# CITY OF PORTLAND BUILDING PERMIT

Located At 12 VESPER

Job ID: 2011-03-570-ADDR

has permission to Renovate house, raise main roof, build 1,320 sf two story addition, with decks  
provided that the person or persons, firm or corporation accepting this permit shall comply with all of the provisions of  
the Statues of Maine and of the Ordinances of the City of Portland regulating the construction, maintenance and use of  
the buildings and structures, and of the application on file in the department.

Drawing: 12 Vesper Street - Second Floor Plan, Existing Date: May 10, '11 Scale: 1" = 6'

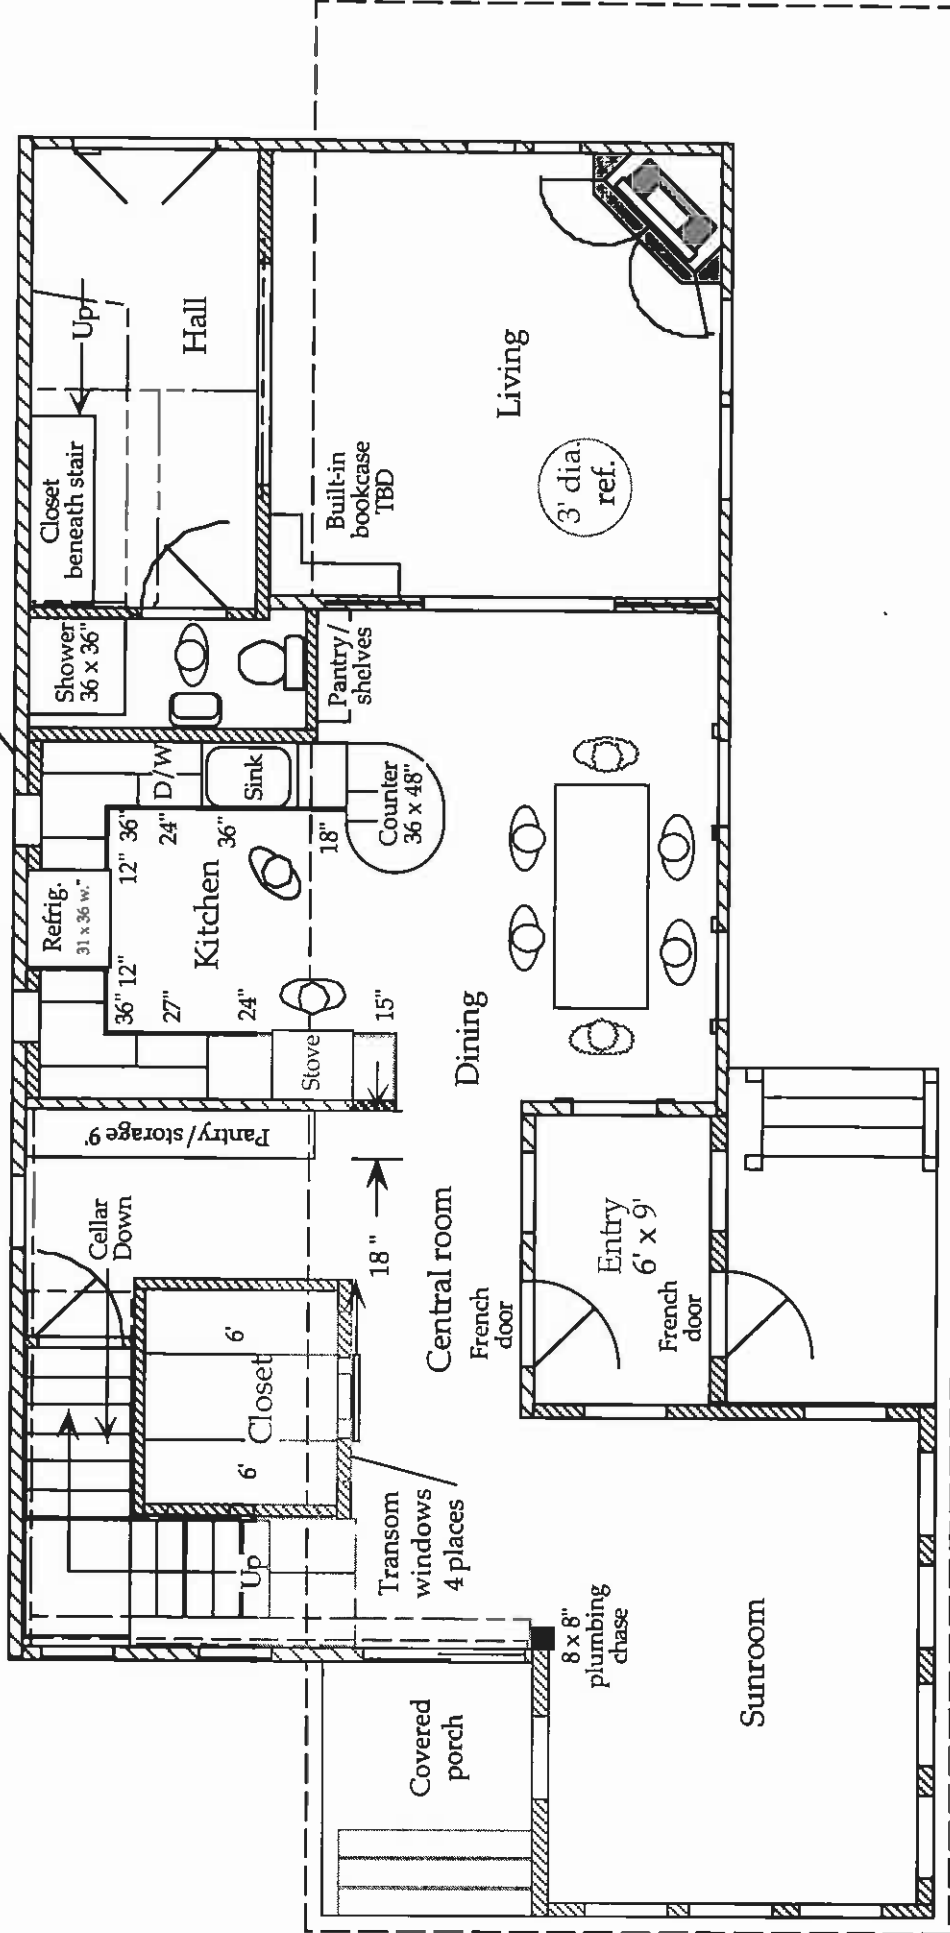
- window fall protection devices
  - continuity of exterior 1 hour rated wall at new stair landing
3. Those renovating single family dwelling shall install a CO detector in each area within or giving access to bedrooms. That detection must be powered by the electrical service in the building and battery.

1. Per Table R302.1 walls <5' from the property line need to meet 1 hour rating with exposure from both sides.
2. Openings in walls (windows) will be allowed even though the building is <3' from the property line, as the building will be sprinkled, and additional sprinkler heads shall be located at each proposed window on the North facing wall.

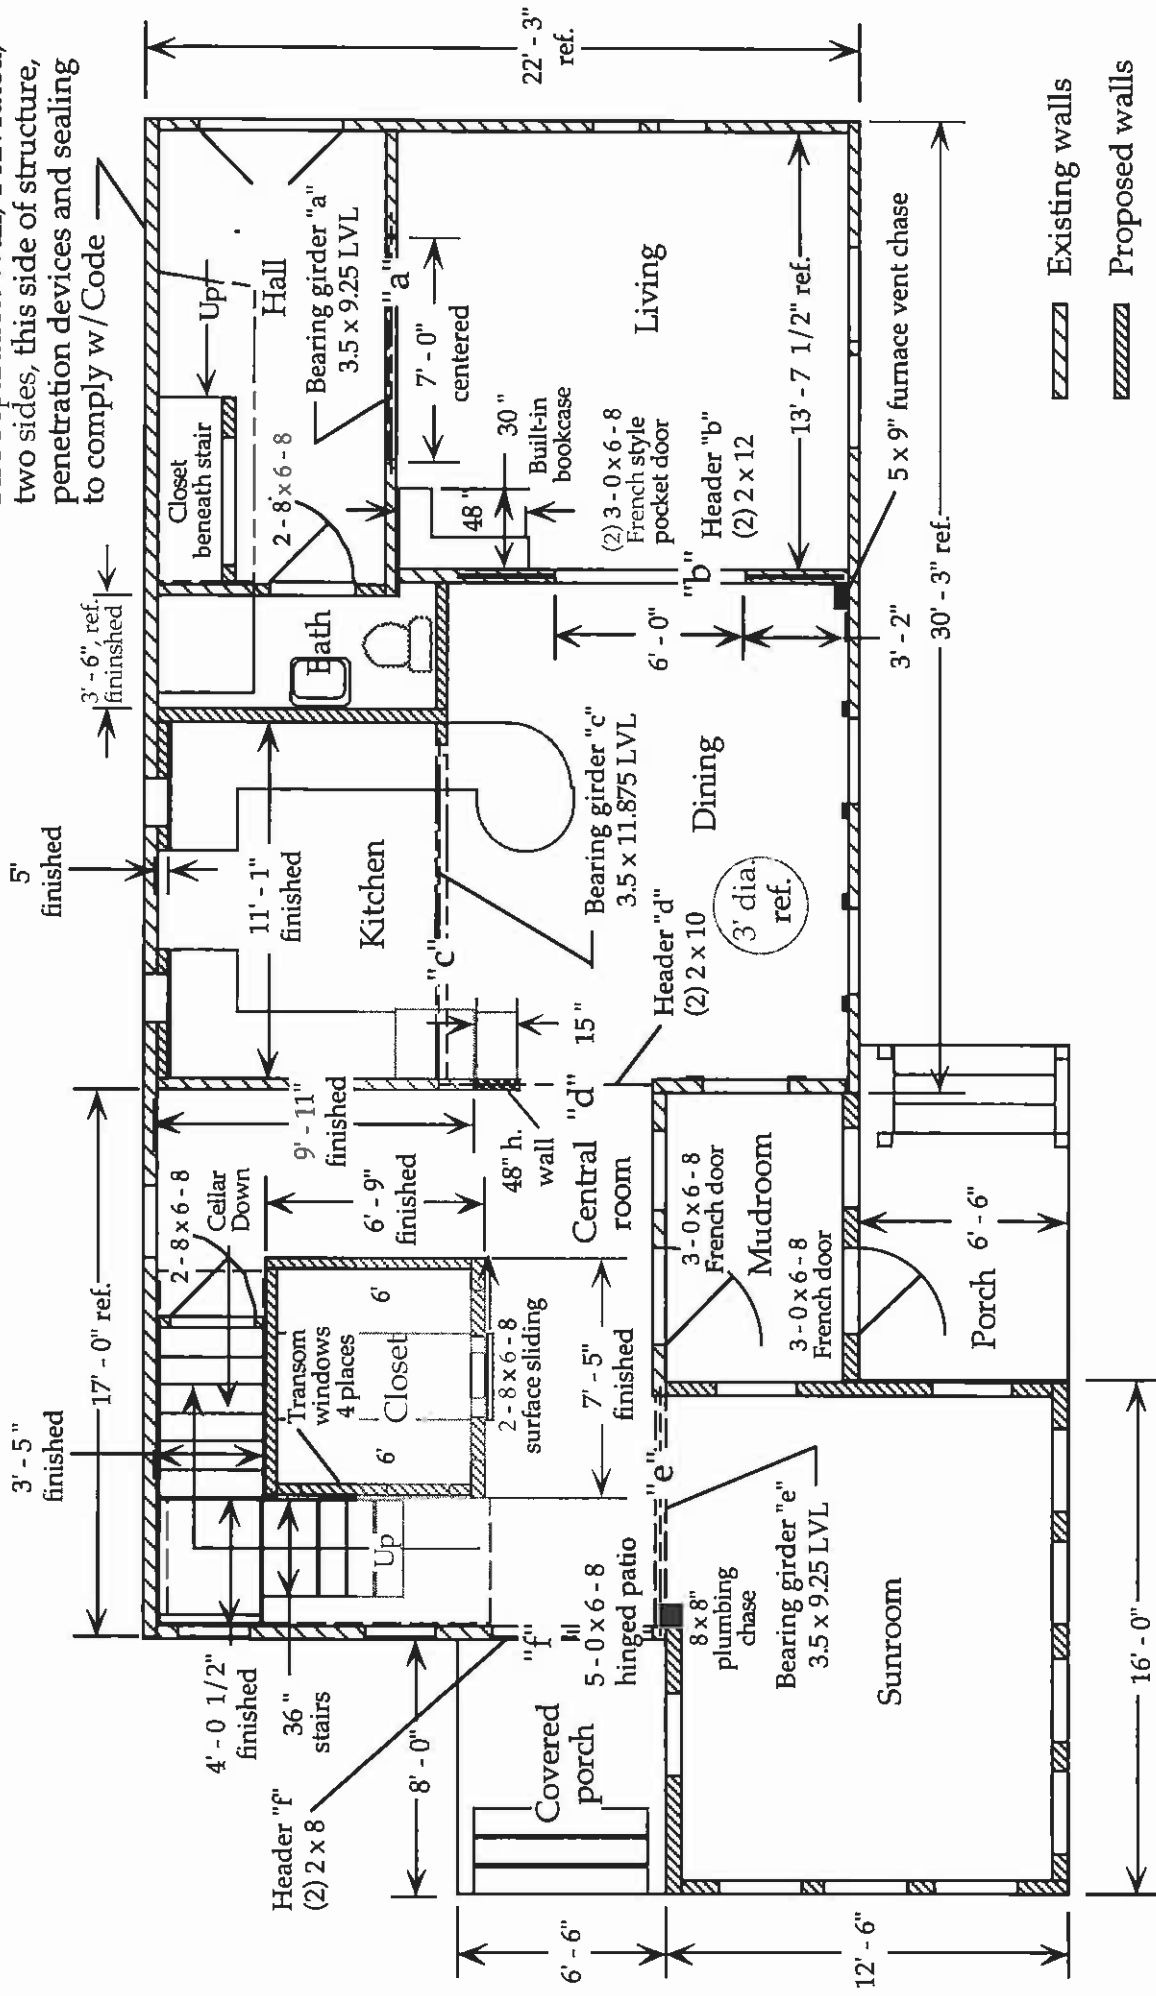
4. Hardwired interconnected battery backup smoke detectors shall be installed in all bedrooms, protecting the bedrooms, and on every level.
5. This is approved using IRC Sec. R104.10 Modifications to allow sprinkler heads to be installed at the windows on the North wall to meet the 1 hour exterior wall fire separation requirements.
